Subject: RE: Planning Consultation on: FG/153/20/DOC

We do not recommend discharge of Condition 2 at this time, and have the following comments:

Application No:	FG/153/20/DOC
Registered:	23rd November 2020
Site Address:	Quercus Nursery Littlehampton Road Ferring BN12 6PG
Description of Works:	Approval of details reserved by condition imposed under ref APP/C3810/W/19/3232525 (FG/35/19/PL) relating to Condition No 2 - surface water drainage.

PROPOSED DRAINAGE LAYOUT
AND DETAILS

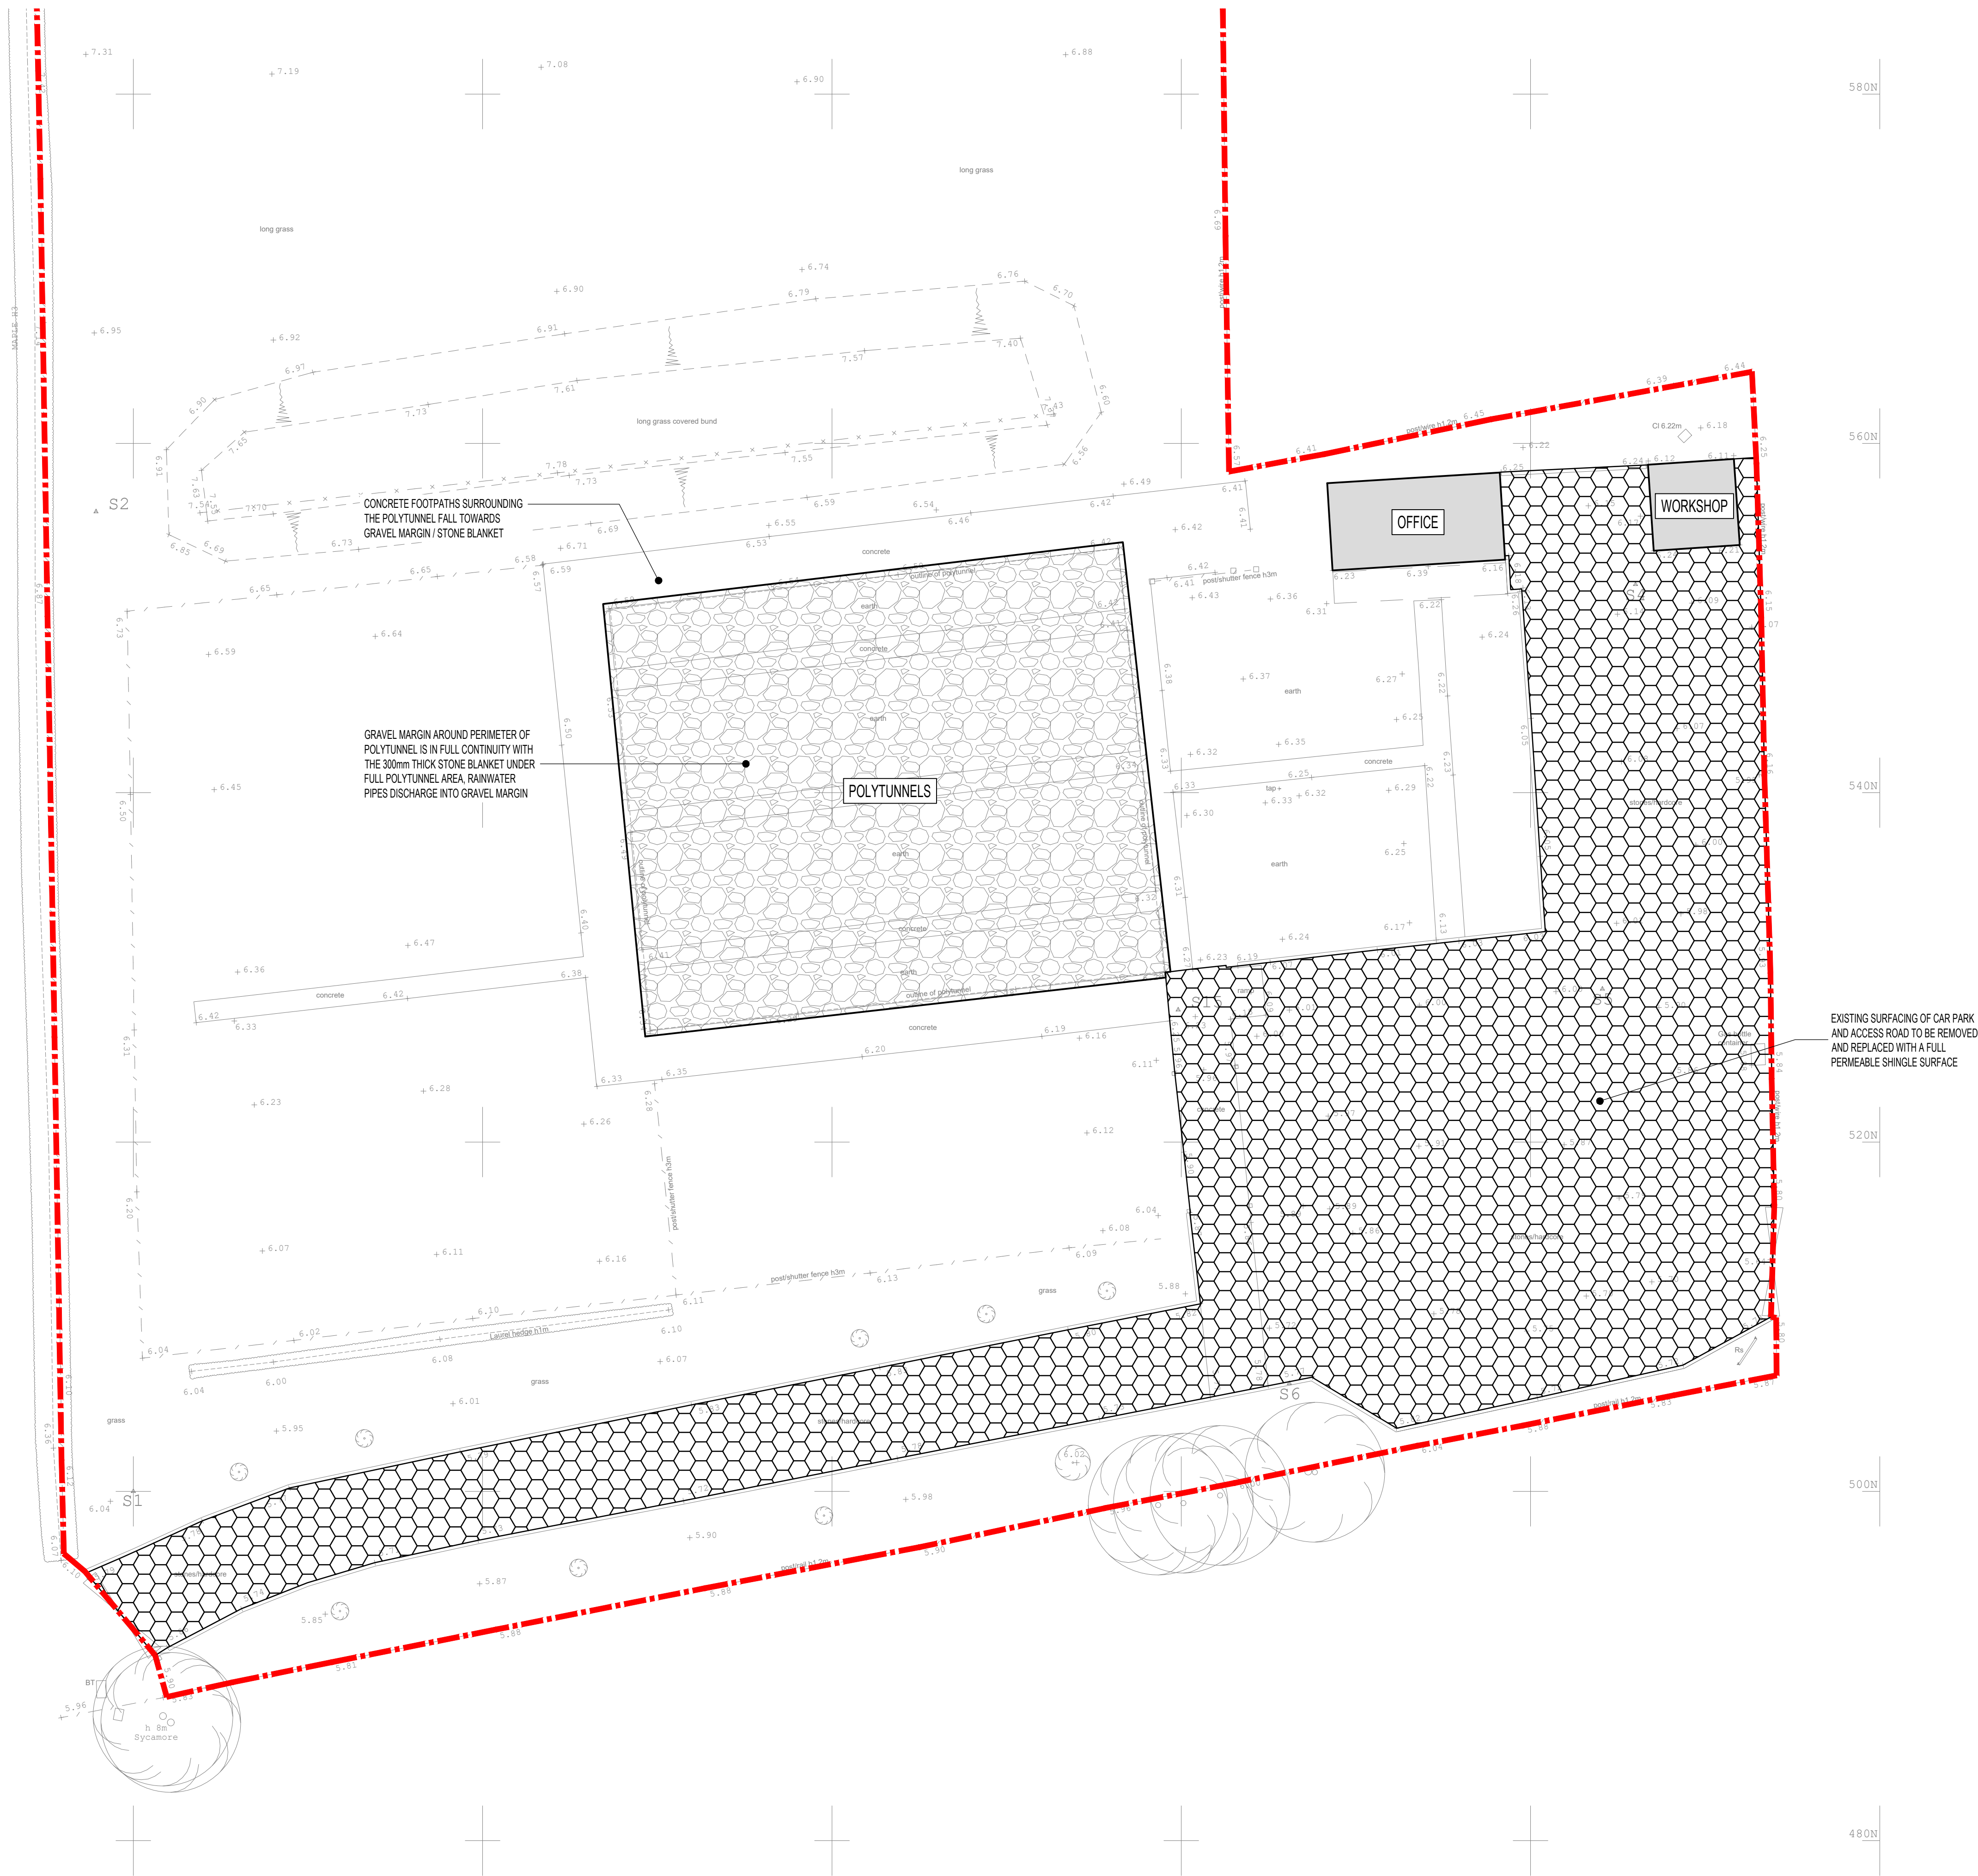
1. Infiltration testing was completed too deep and not in accordance with BRE365. One test was completed in each location only, and water failed to drain to 25% level. The infiltration tests were completed below groundwater level and not at the depth of the proposed infiltrating features.
2. No calculations have been supplied to support the design.
3. No construction detail drawings have been provided.
4. The layout plan does not detail the required depth of the car park sub-base.
5. The layout plan needs to clearly state whether permeable storage areas are to have flat sub-bases or not.
